Aldwick Parish Council
Ms S Batey
Aldwick Parish Offices
88 Pryors lane
Aldwick
PO21 4JF

Proposed garage.
4 Arun Way Aldwick

Thank you for your internet comments of objection made on 18th February 2009 and recorded as follows:

PROPOSED FRONT ELEVATION STREET SCENE - NORTH WEST

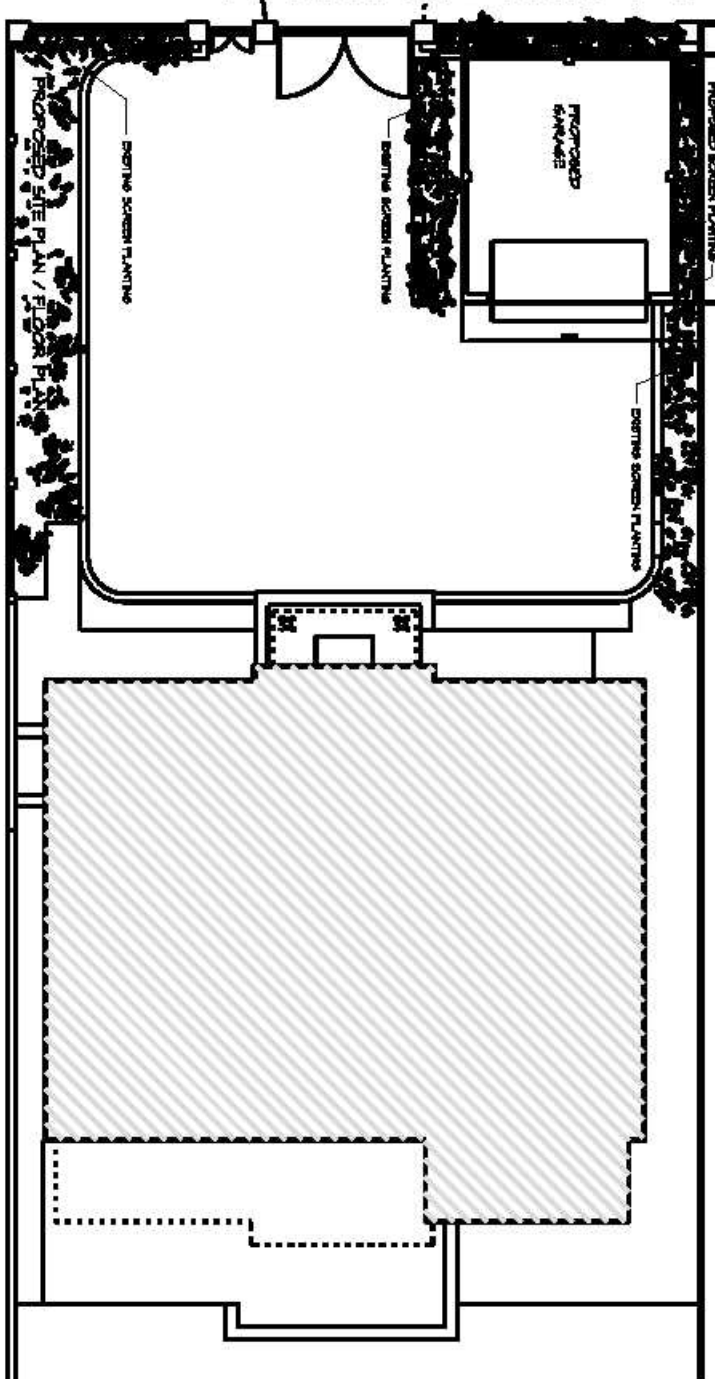
Members felt that the proposed garage to the front of the property would adversely effect the visual amenities of the area. The proposal is therefore contrary to the policies DEV1, CH1, LOC1 of the West Sussex Structure plan and policy Gen 7 of the Arun District Council local plan. ☐
